DRB Application No.: 10DRB-70095 Project # 1008137  
Project Name: Westgate Heights Subd.  
Agent: DSA Architects LLC Phone No.: 342-6200

**FILE: Project 1008137  
10EPC-40004 Amended Site Development Plan for Building Permit**

**RE: San Martin de Porres Parish – 8301 Camino San Martin SW**

This is a request for approval of an Amended Site Development Plan for Building Permit for the San Martin de Porres Parish expansion project. This Amended Site Development Plan was approved by the EPC on February 19, 2010 (1008137/10EPC-40004).

CONCEPTUAL SITE PLAN
 1" = 30'

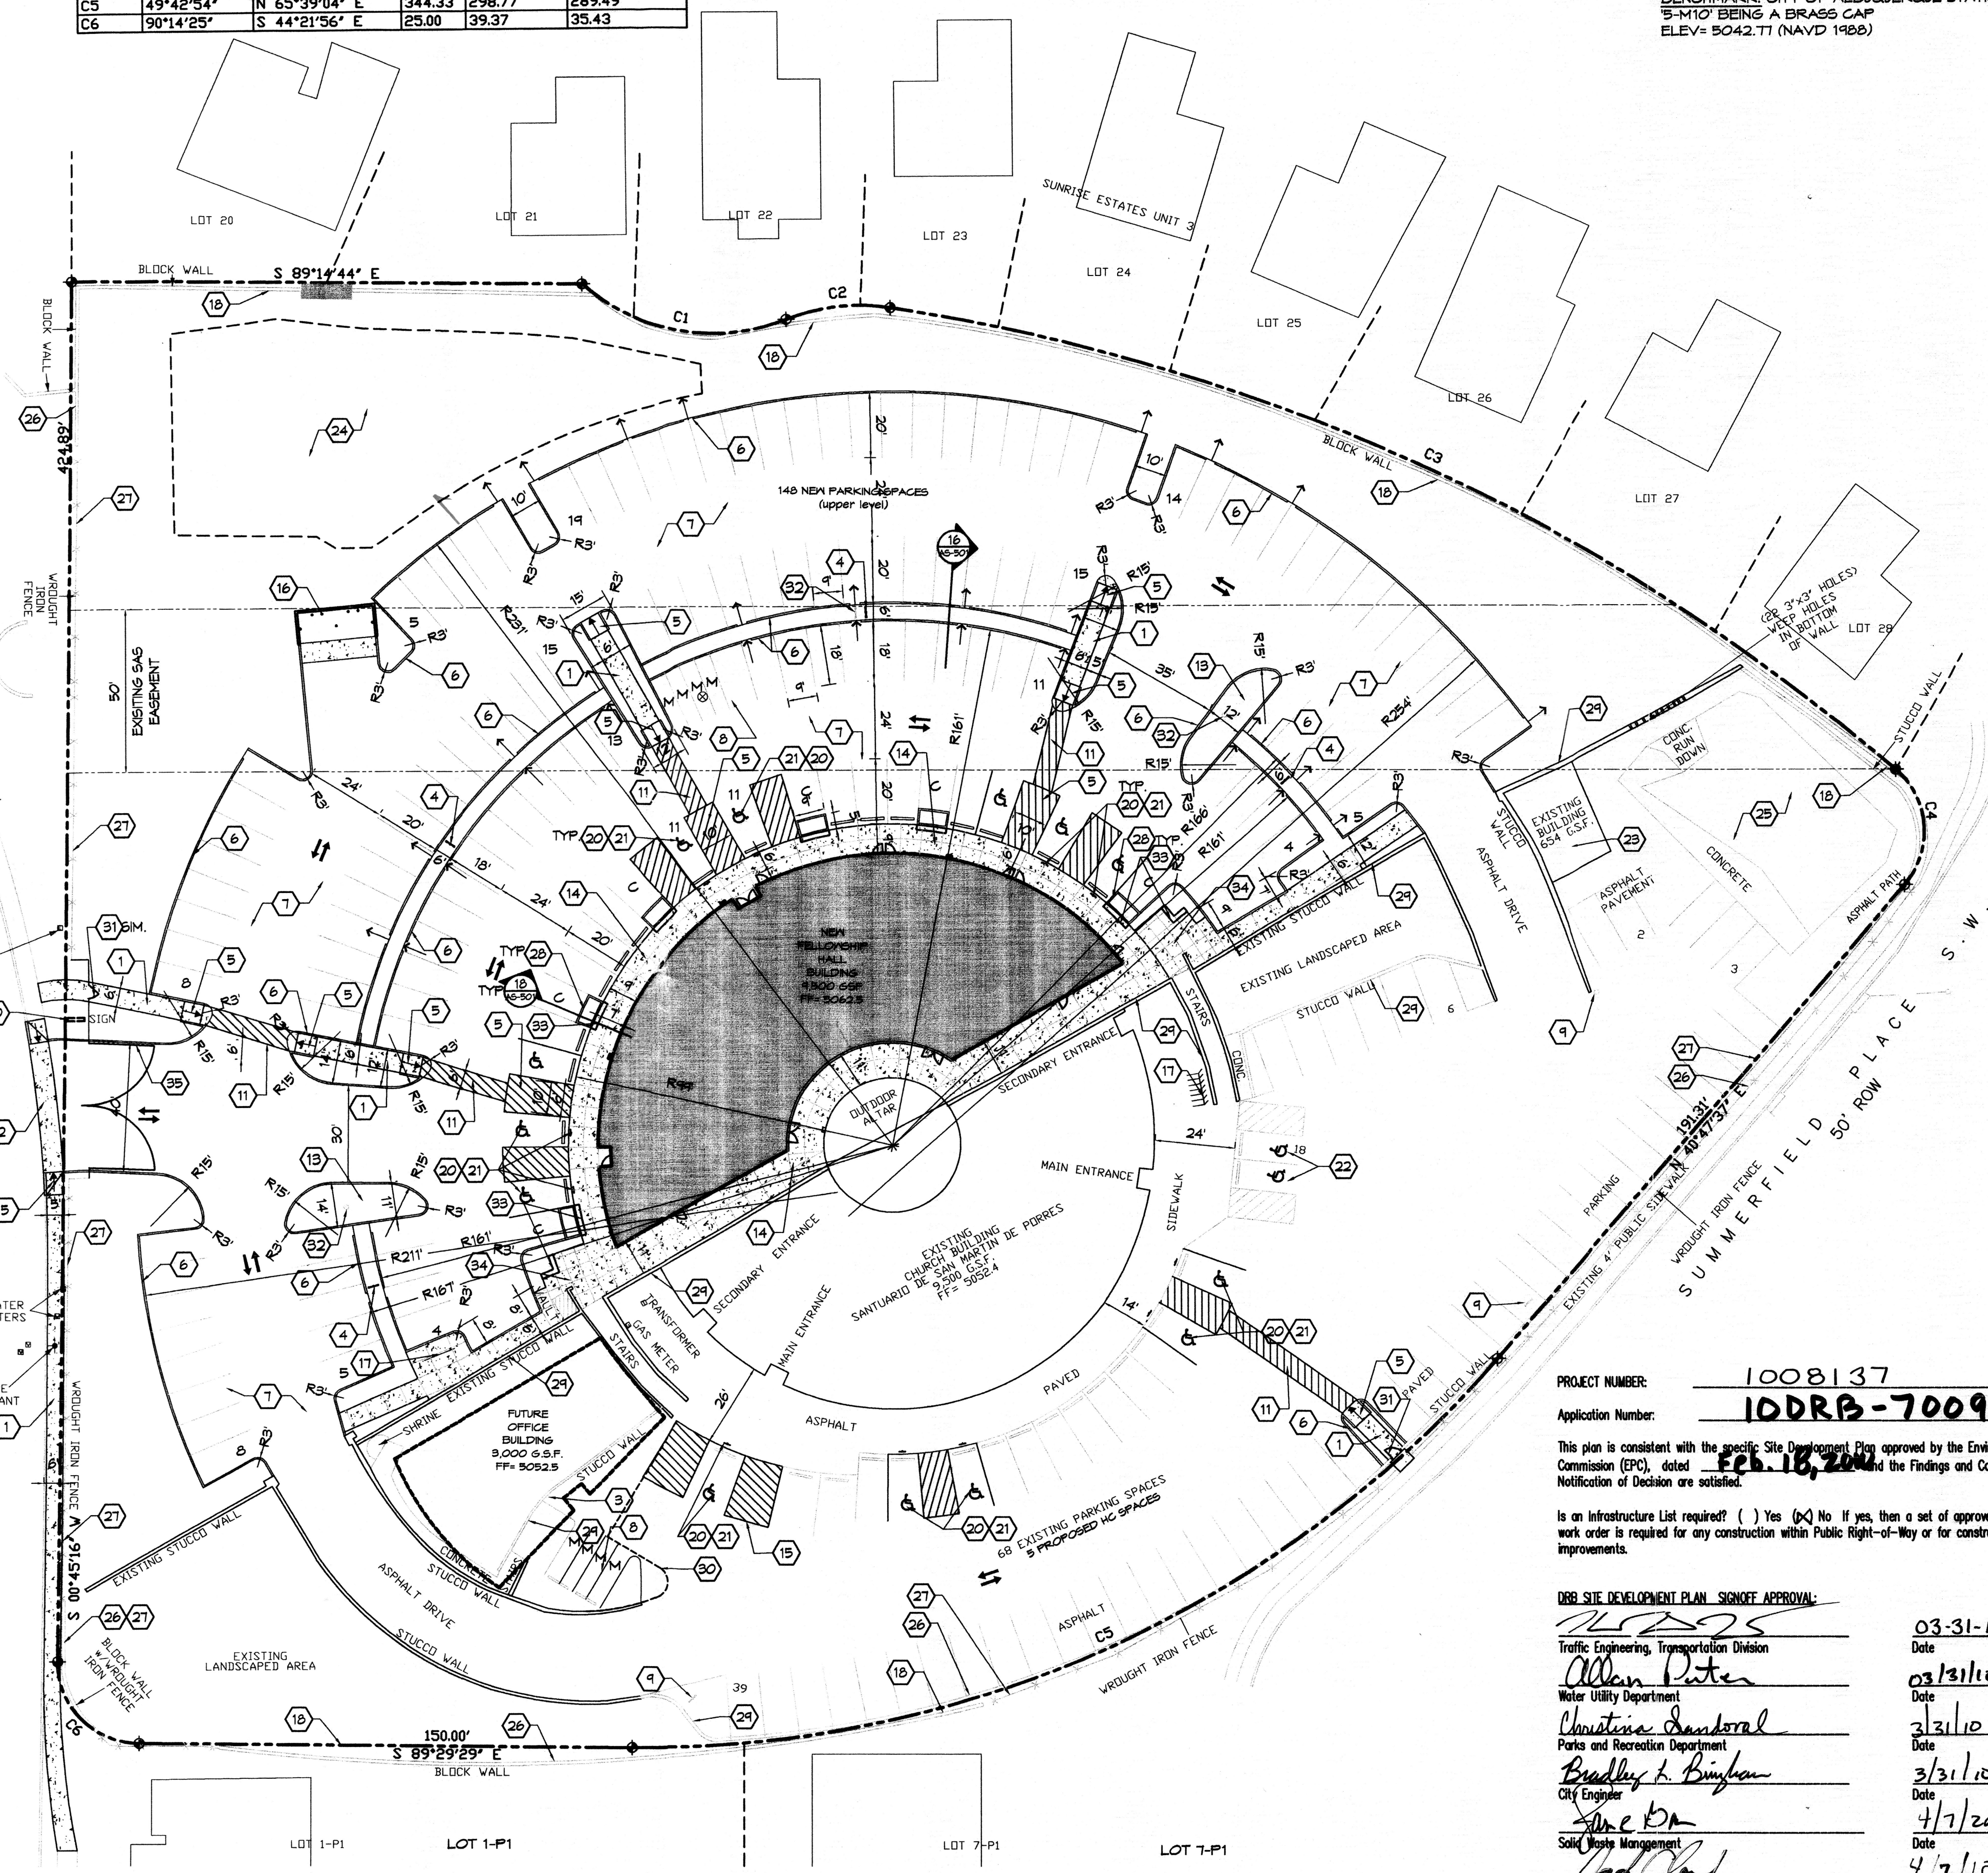
1. The conditions of delegation to the DRB for the Amended Site Development Plan for Building Permit are understood and will be adhered to in accordance with the approval.
2. Our team has met with Carol Toffaleti, Staff Planner.
3. The conditions of delegation to the DRB for the future office building are understood and will be adhered to in accordance with the approval.
4. Conditions from City Engineer, Municipal Development and NMDOT:
  - a. There are no transportations facilities adjacent to the site.
  - b. We respectfully request that the client be granted authorization to relocate the fence within the property line at the time a building permit is issued for the expansion project. The sign has been relocated on the Amended Site Plan within the property line of San Martin.
  - c. The Site Plan shall comply with the DPM standards.
5. Site Development Plan (sheet 1-AS-101)

- a. The word "office" has been added to specify the use and the gross square footage has been added.
  - b. The free-standing sign has been relocated within the property line and called out on the Site Plan.

- b. The number of new parking spaces on the upper level and proposed spaces on the lower level has been called out.
  - c. One motorcycle parking space has been added in a location visible from the main entrance to the church.

- d. Keyed Note 8 has been changed.
  - e. The existing disabled parking signs in front of the church have been called out.
7. Pedestrian access and circulation:

- a. A gate and walkway have been added to the fence on Summerfield Place.
  - b. The crosswalks have been changed to thermoplastic.
  - c. The bike rack has been repositioned to maintain a minimum 6' clear.

8. Lighting
- a. General Note B on sheet AS-101 has been changed
  - b. General Note F has been added to sheet AS-101.
  - c. Existing light poles being retained or removed have been called out.

16 TYPICAL CURB CUT DETAIL

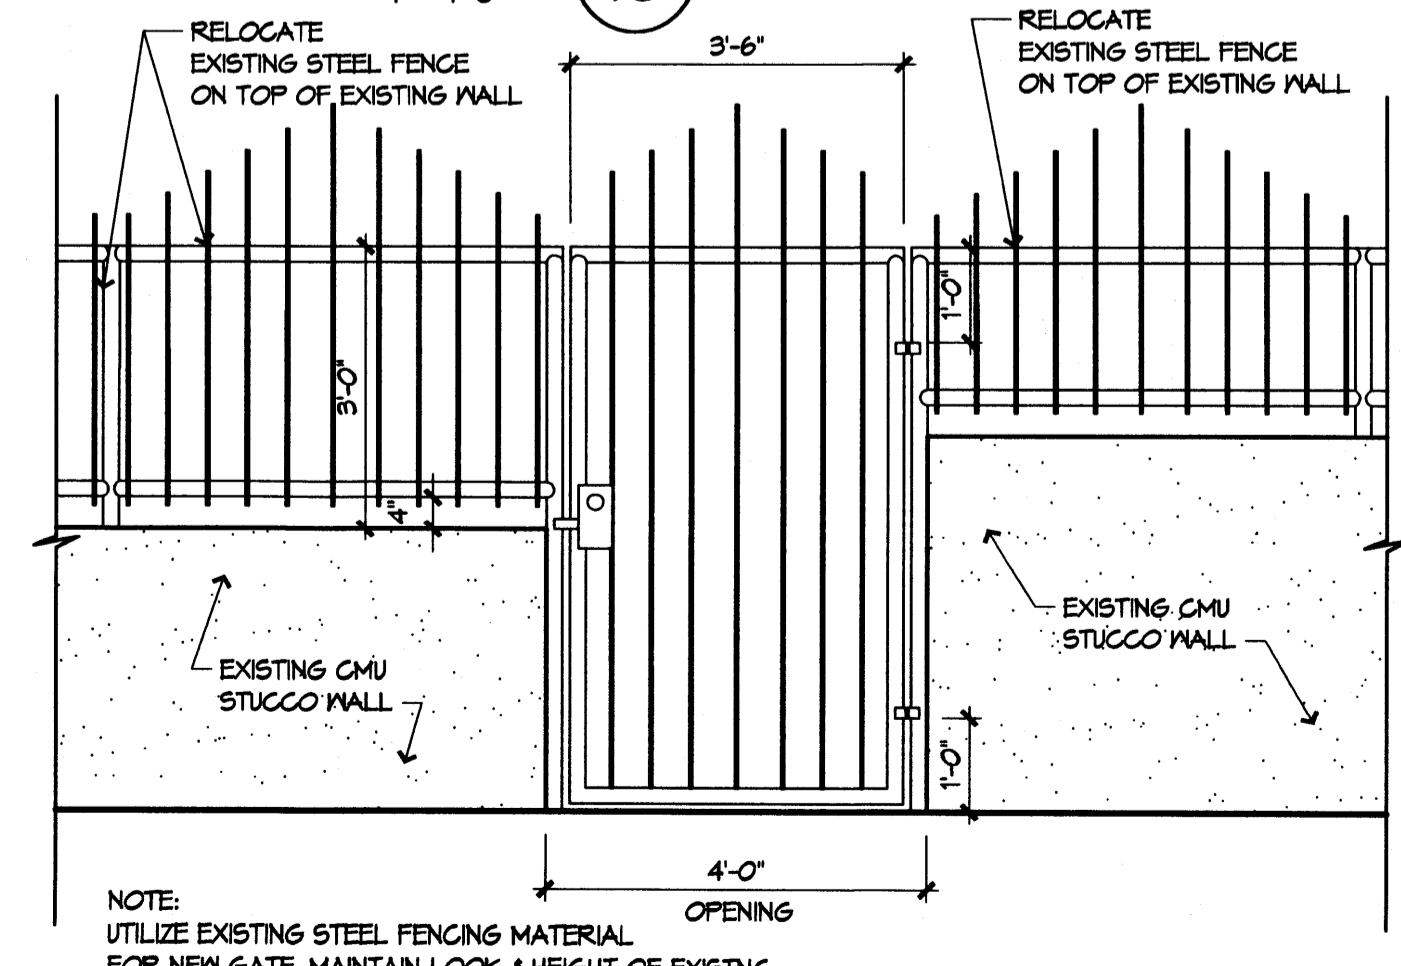
- c. The curb cut detail and cross-section have been moved to sheet (AS-501).
6. Parking
- a. Calculations
    - i. We have specified "fellowship hall" and "office" to identify the uses of the buildings.

L-100

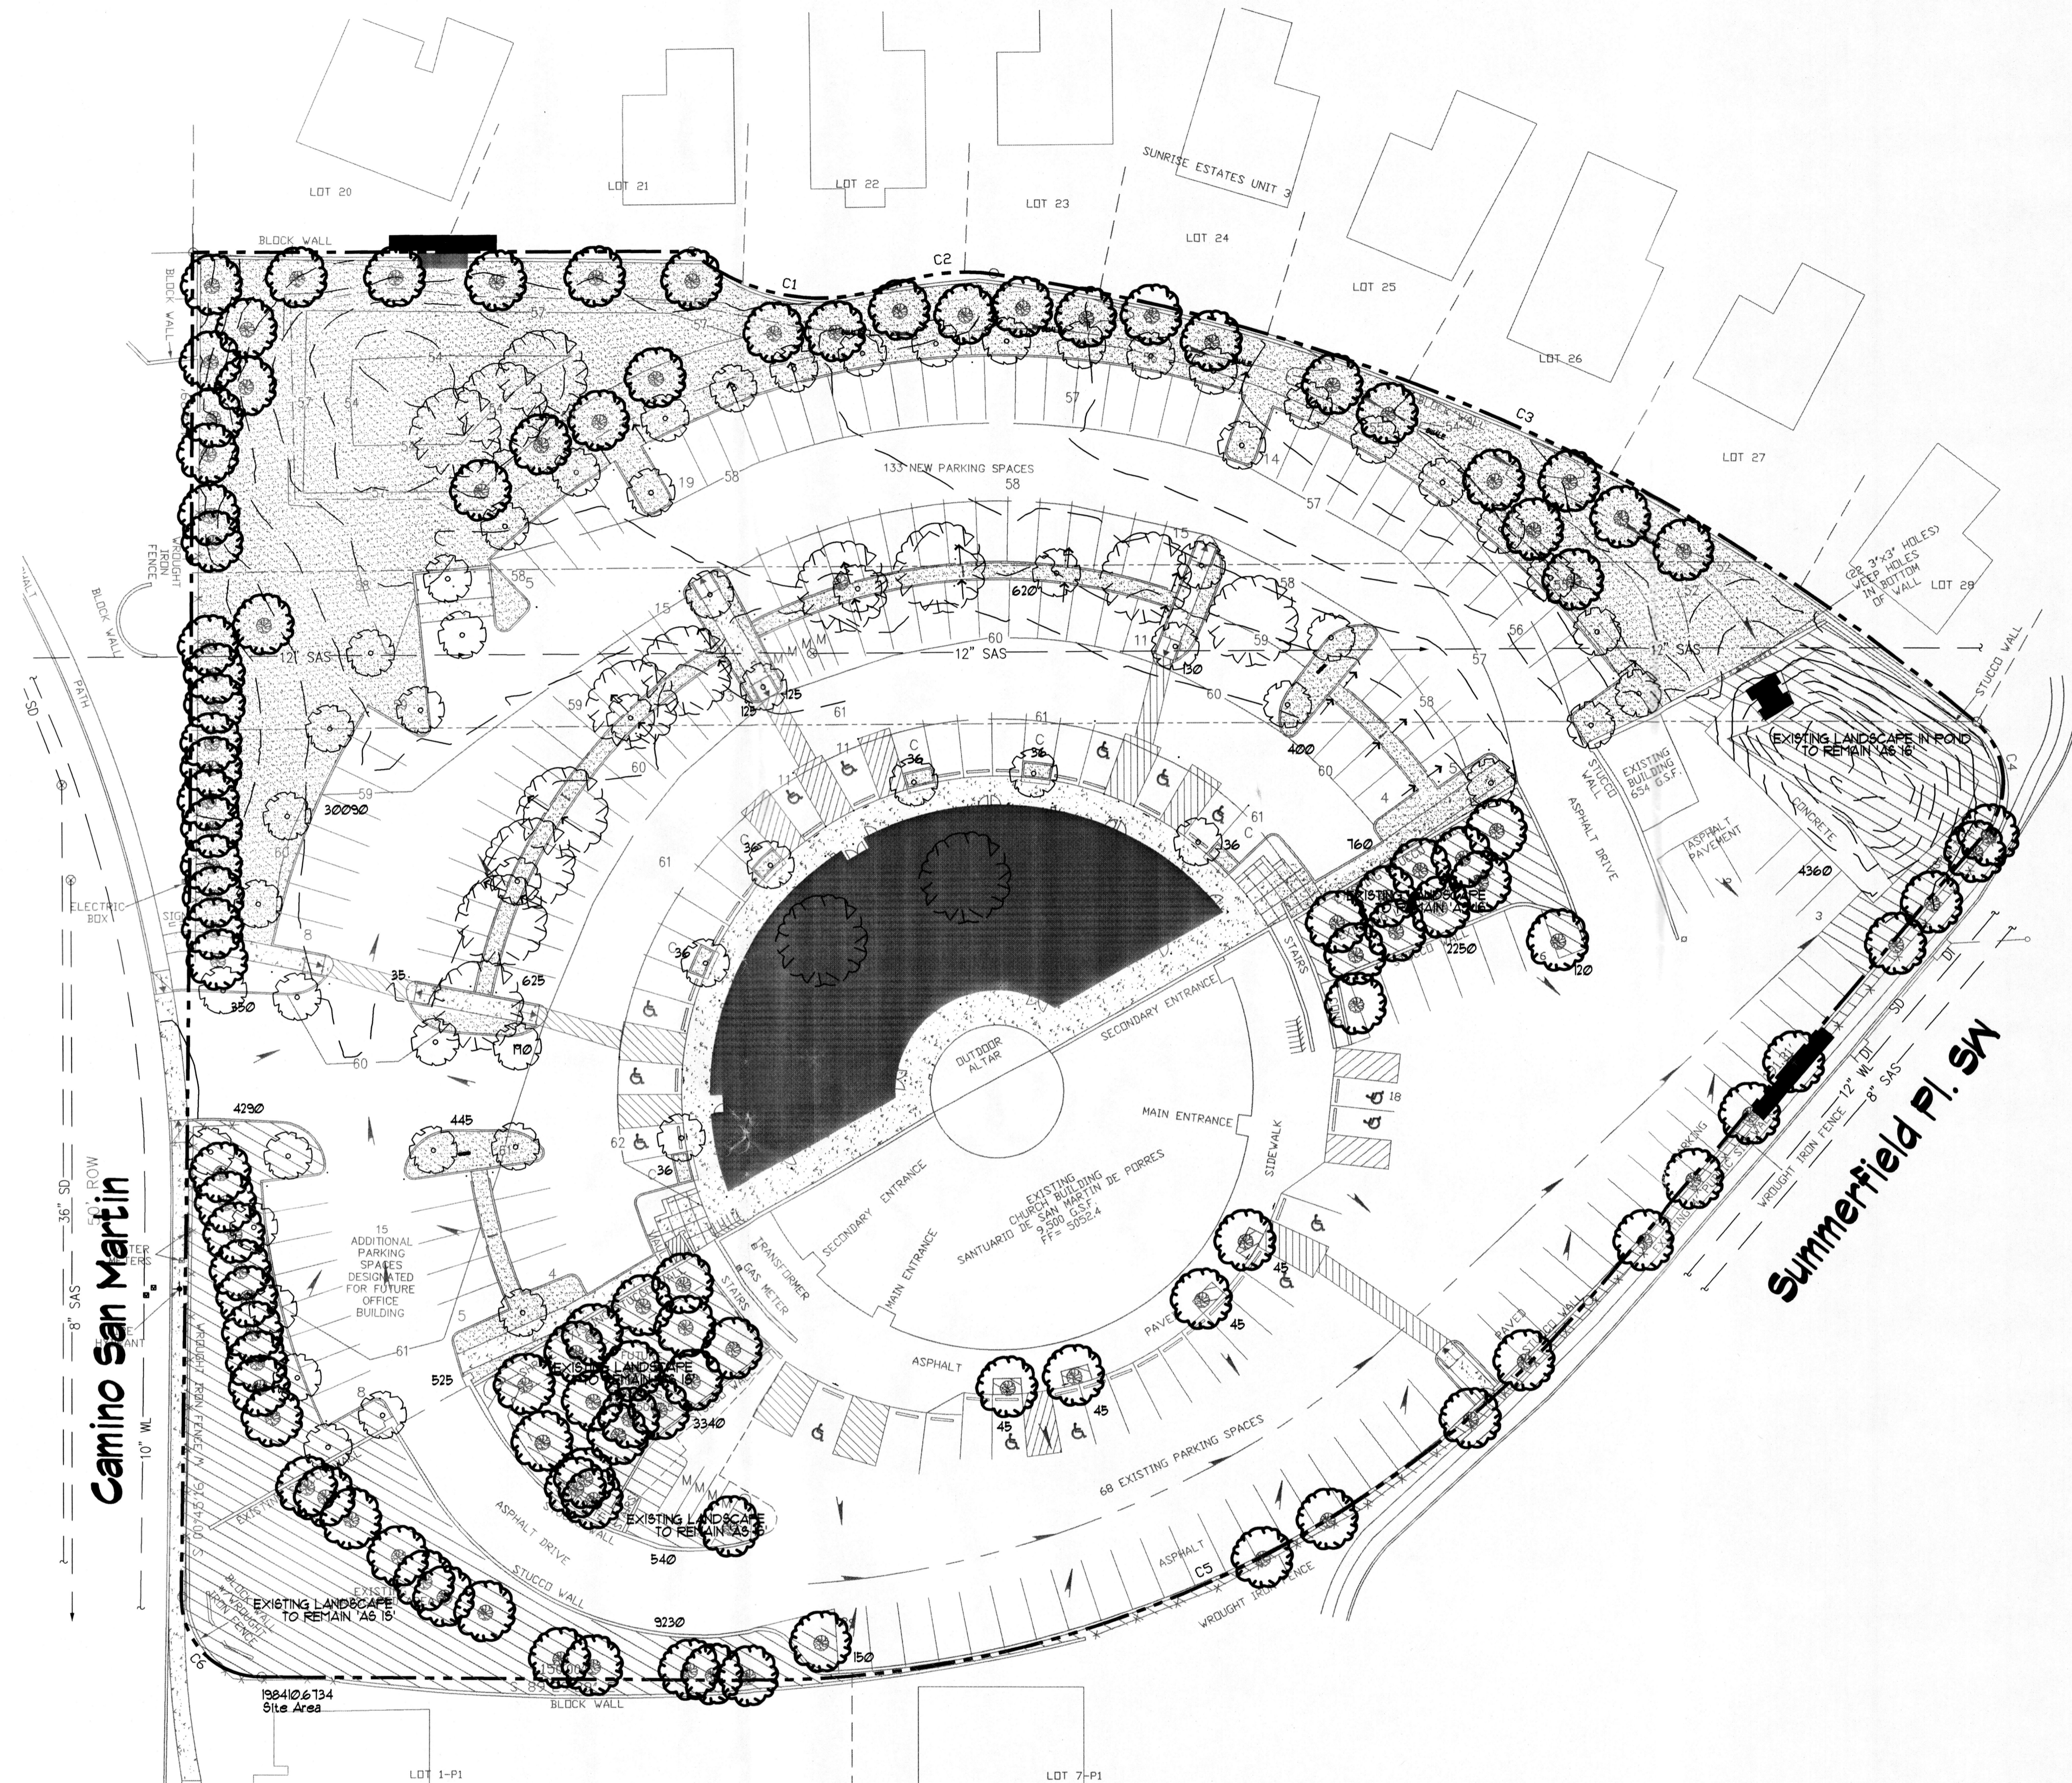
- d. Building mounted lighted has been added to sheet A-201.
9. Landscaping
- a. Existing landscaping on the north part of the site has been hatched.
  - b. Parking area tree calculations have been corrected.

- c. The SAS easement note has been enlarged.
  - d. Landscaping calculations have been revised and clarified.
  - e. Square footage figures are consistent throughout the submittal.

- f. Calculations for Phase II have been added.
10. Outdoor Amenities:
- a. Seating has been added along the circular frontage of the fellowship hall.
  - b. Two patio areas have been added with seating and shade trees.
